RE: Longfellow Parking Garage and City Parcel Development
Portland, Maine

Gorrill-Palmer Consulting Engineers, Inc. is pleased to respond to the review comments made by Tom Errico of Wilbur-Smith Associates and Jim Carmody dated March 31, 2006 regarding the above referenced project. For ease of review, each comment has been repeated below followed by our response.

India Street at Middle Street

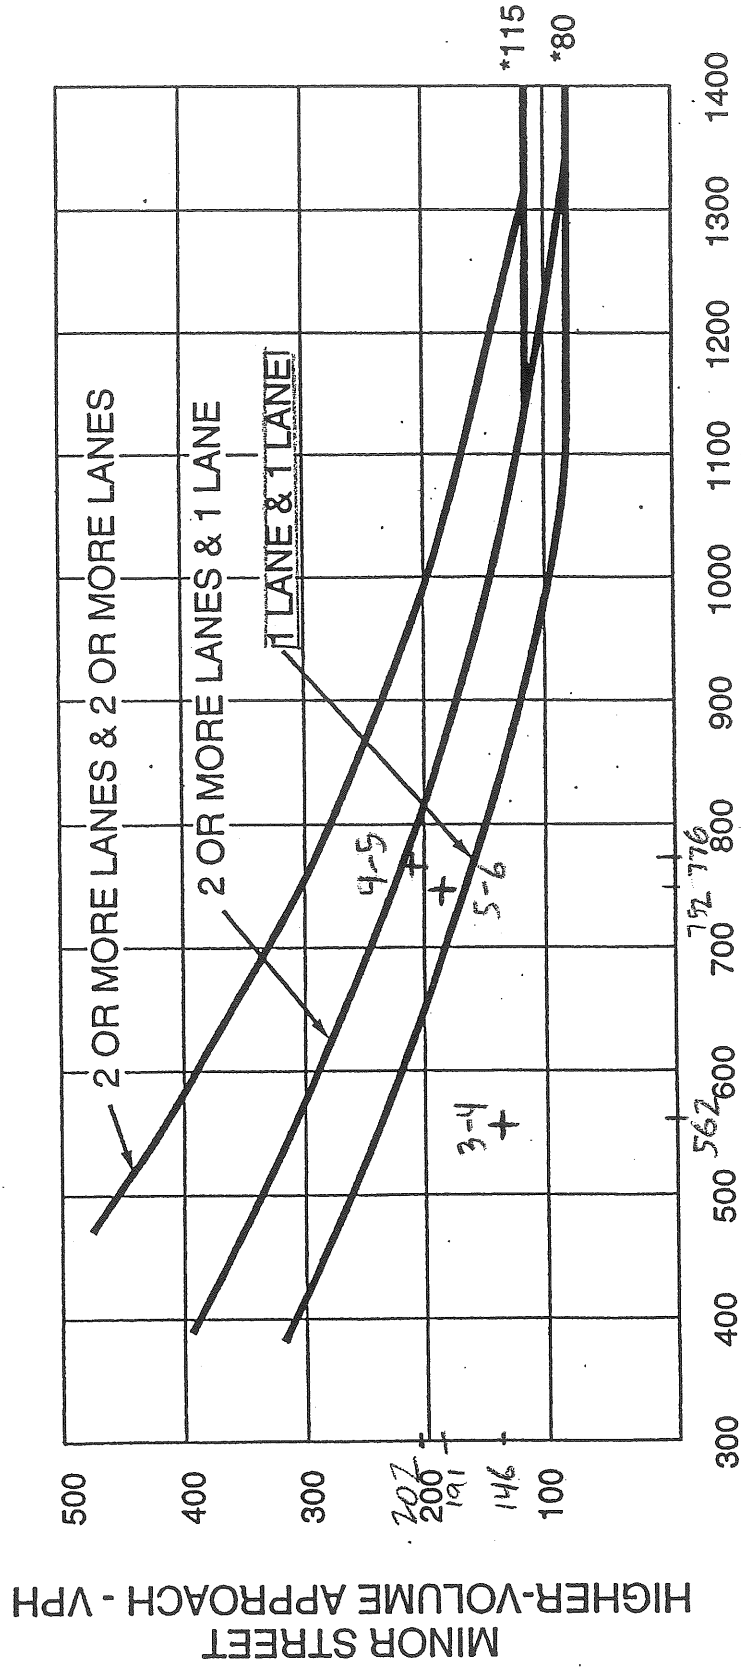
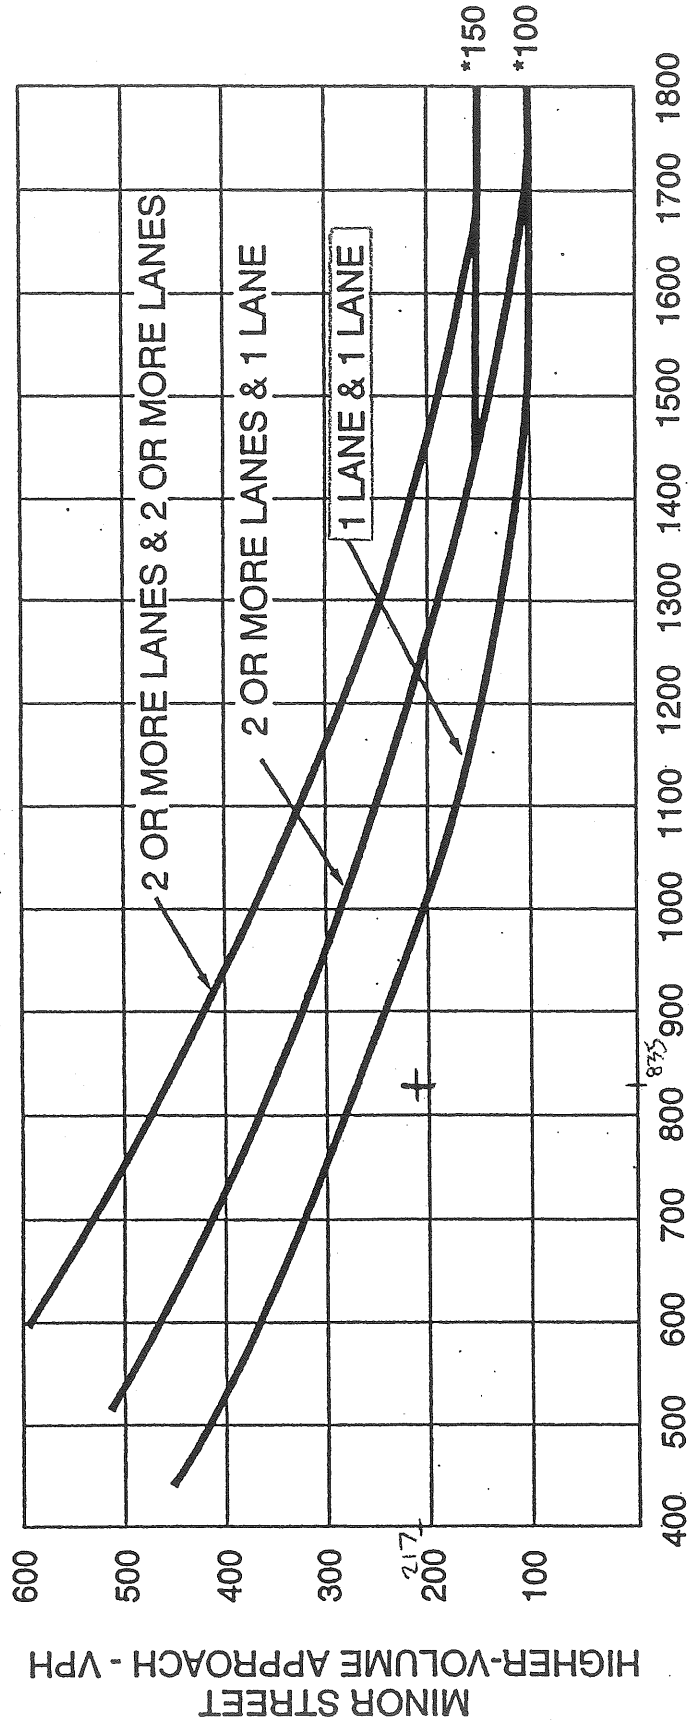
Comment 6 – The Applicant should evaluate the feasibility of providing a multi-way stop sign installation at the India Street/Middle Street intersection. The Applicant should assess whether the intersection meets MUTCD warrants and assess queuing issues on India Street between Middle Street and Fore Street.

Response – Our office examined the potential for a multi-way STOP intersection at the intersection of India Street and Middle Street. Based on the warrants detailed on Page 2B-8 of the MUTCD, the following criteria should be considered prior to installation of a multi-way STOP:

Based on a review of the intersection, the intersection does not satisfy criteria B. Although the minor street volumes referenced for the purposes of a traffic signal did not include the right turns, these would be included in the warrant for a multi-way stop. Although only three hours of data were available, is it the expectation of our office that at least eight hours of forecast traffic would satisfy the warrant. The volumes for this analysis were originally compiled in the traffic impact study and can be found in the appendix of that report. In addition, installation of a multiway STOP intersection would satisfy Other Criteria B and D. Although not currently residential, this portion of the City will be increasingly so in the future. Therefore, it is the opinion of our office that installation of multi-way stop control is warranted.

Therefore, it is the opinion of our office that a multi-way stop treatment should be placed at this intersection. As forecast in the Eastern Waterfront Master Plan, this location will ultimately require a traffic signal, but as the forecast approach volumes with this project, the Village Project, the Ocean Gateway and the Westin site will not trigger the signal warrants, the signage will serve this intersection for the near future.
